City of Albuquerque

June 21, 1995

**RE: DRAINAGE PLAN FOR ALB COORS CELL SITE (H-11/D50)
RECEIVED MAY 31, 1995 FOR SITE DEVELOPMENT PLAN
ENGINEER'S STAMP DATED 5-30-95**

RE: DRAINAGE PLAN FOR ALB COORS CELL SITE (H-11/D5)
RECEIVED APRIL 24, 1995 FOR SITE DEV PLAN & BLDG PRMT
ENGINEER'S STAMP DATED 4-20-95

DRAINAGE PLAN

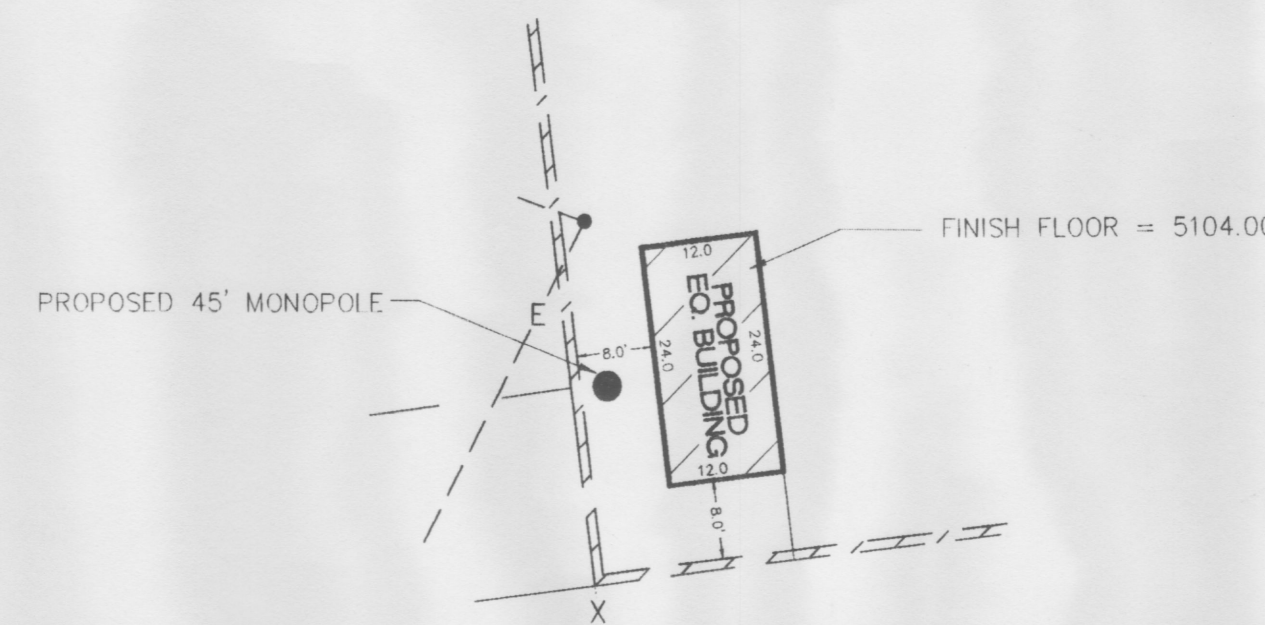
Why is a Drainage Plan required? The addition is less than 500 sf. If a Drainage Plan is required it must be per the DPM checklist. Indicate finish floor, top of concrete pad and top of sidewalk elevations. Provide top of curb & flow line elevations on Vista Grande & Alamogordo Drives. Label the each contour. Based on the limited number of contours, it is impossible to tell which direction the site slopes.

Which F.I.R.M. panel is the site on? Is the site in or adjacent to a FEMA, 100 year flood hazard zone? How does the substation drain to Vista Grande? Include flow arrows and proposed concrete work in the Legend.

1. Per a condition of site development plan approval, a drainage plan and hydrology approval is required.
2. Finish floor elevation have been added to drainage plan.
3. Flow line elevations on Vista Grande and Alamagordo Drives have been added.
4. Each contour has been labeled.
5. Flow arrows to indicate direction of flow have been added to both plan and legend.
6. F.I.R.M. panel and FEMA 100yr floodplain have been addressed on the plan.
7. The substation is enclosed by a block wall and all flows are contained within the substation, producing no flows from the substation to Vista Grande.
8. Proposed concrete work is shown on legend.
